From: Martin Farrer [REDACTED]
Sent: 19 October 2020 [REDACTED]
To: Sian Eggington
Subject: RE: Request for further information FP/182/20/HH
Attachments: We sent you safe versions of your files; 3249_P_03A - location and block pdf.pdf

Job No: 3249
Dwg No: P_02

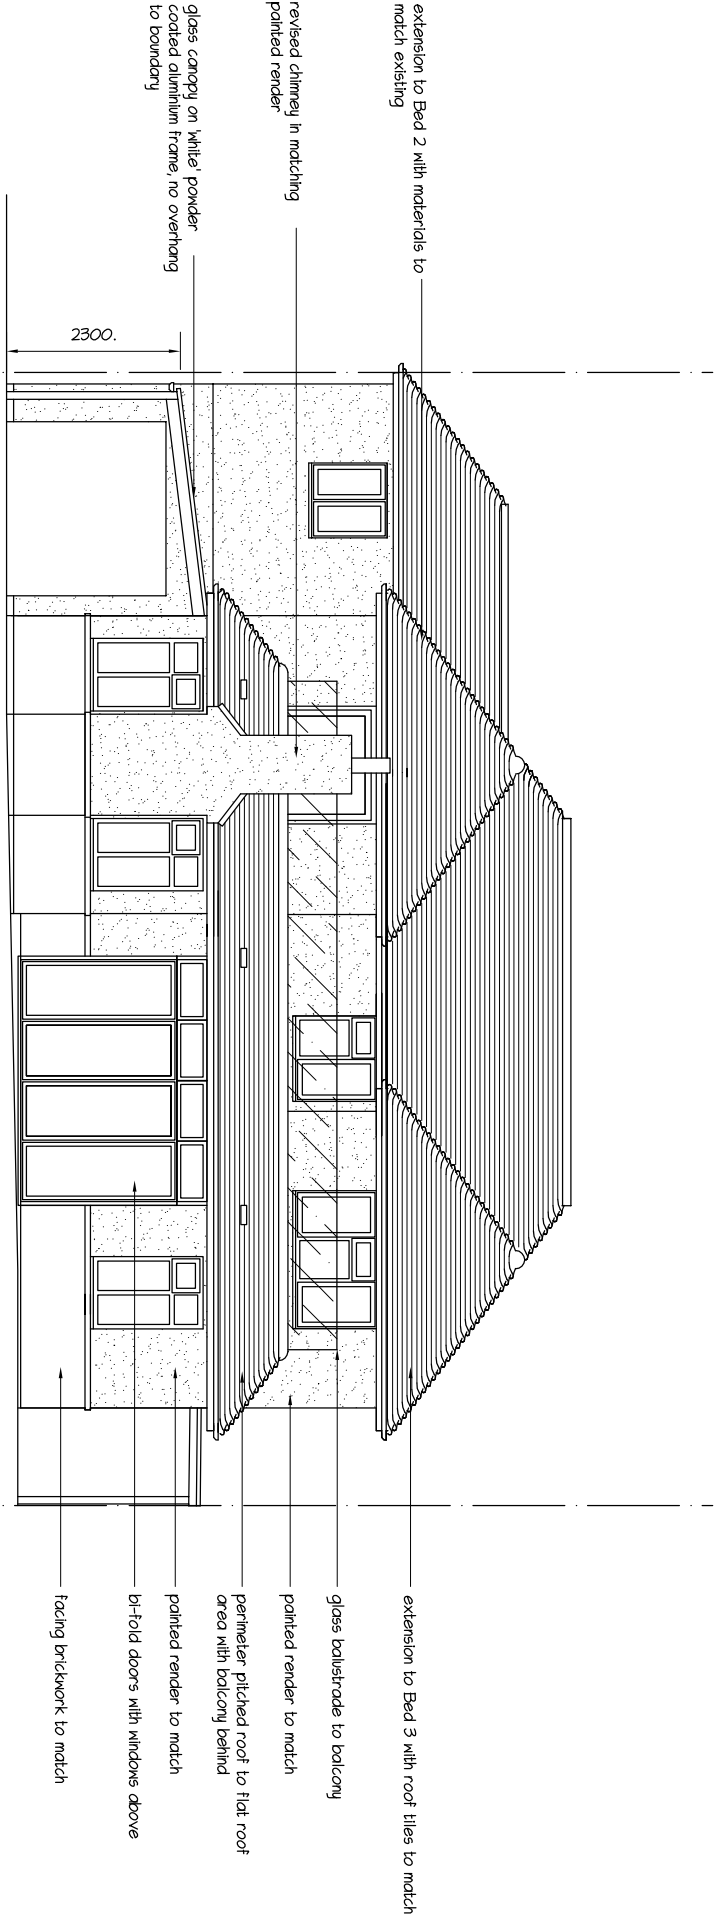
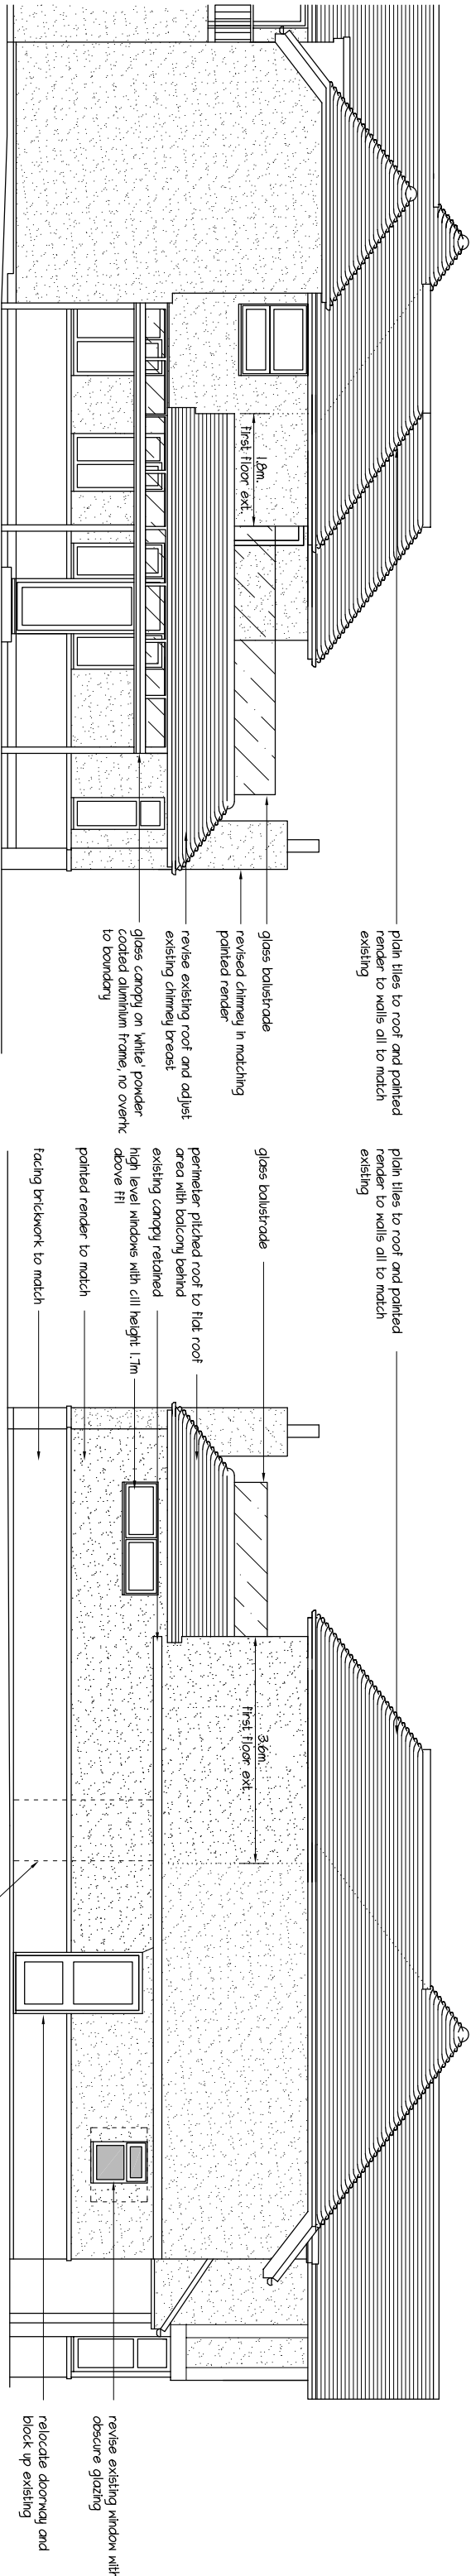
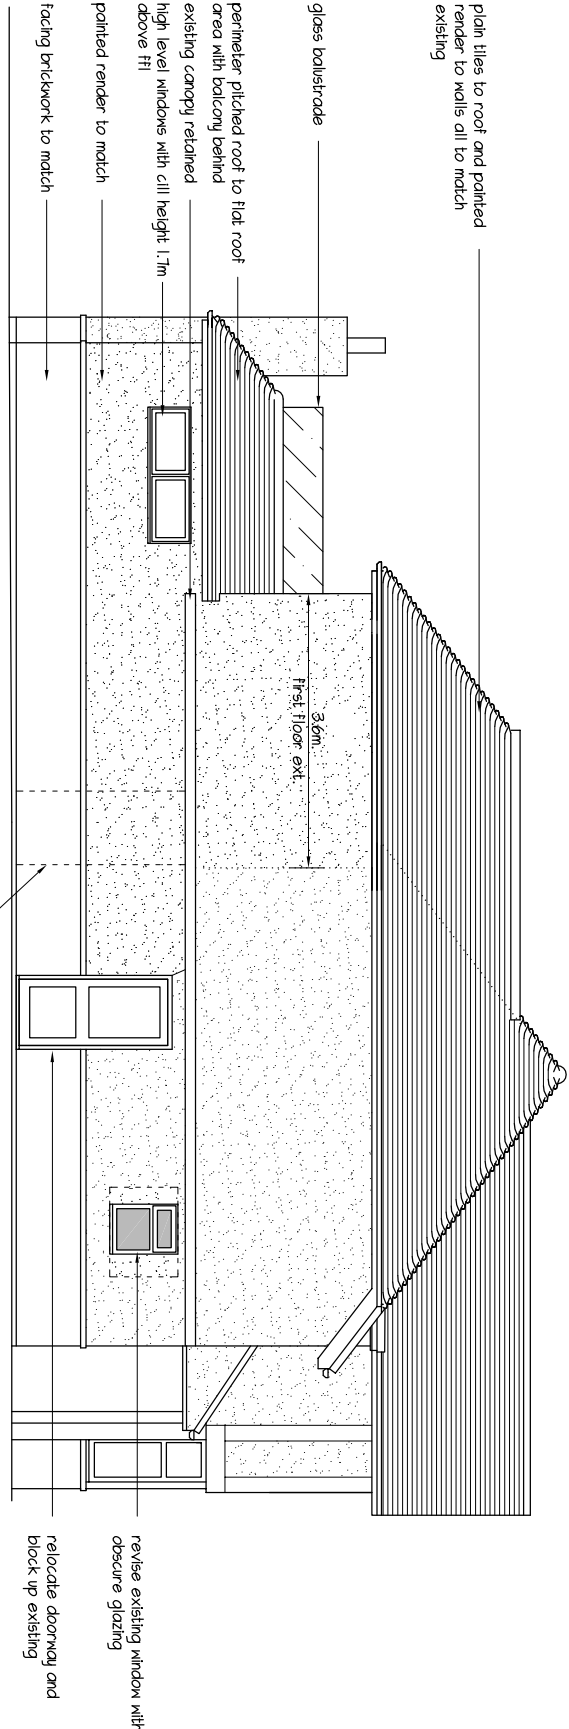
Please can you clarify which 'other' side elevation is required as requested in your letter dates 19th Oct 2020? Do you mean the south elevation of Bed 3, which is slightly obscured by Bed 2 on the proposed south as shown. Or do you mean the north elevation of Bed 2 which is fully obscured by Bed 3 in the north elevation as shown? If you want the front west elevation then I can confirm there is no change to the existing front elevation, so proposed is equal to existing.

Job No: 3249
Drg No: P_03 A

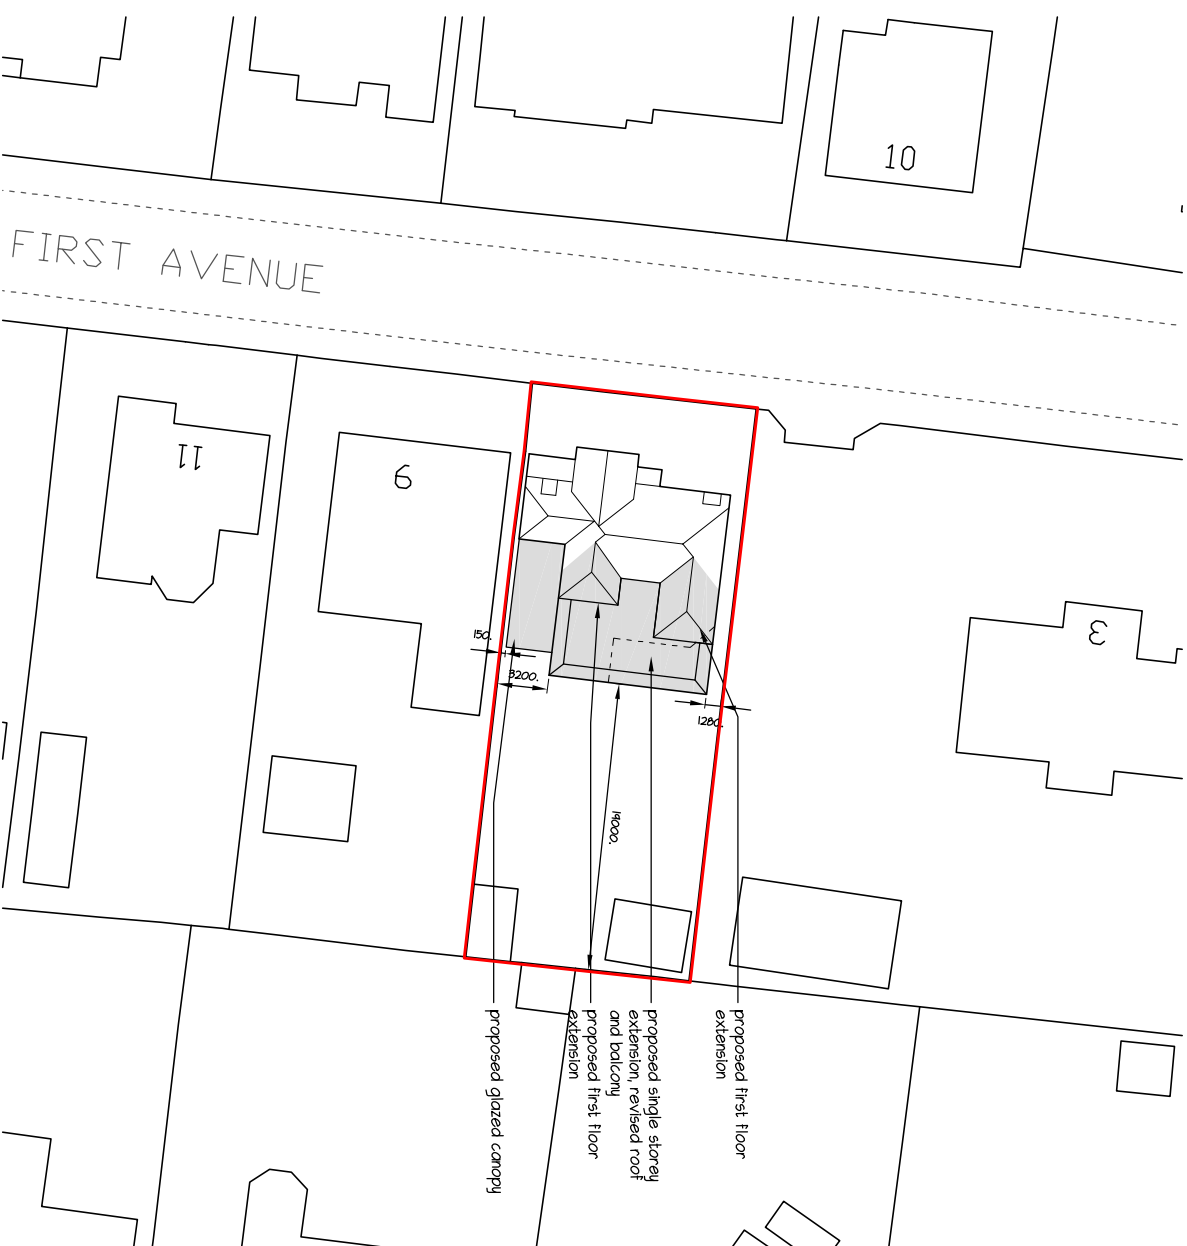
As you have confirmed no changes will take place we will not require an additional elevation. However the dimensions are required with your permission I can add these for you.

Thank you for confirmation. I attach block plan with dimensions attached.
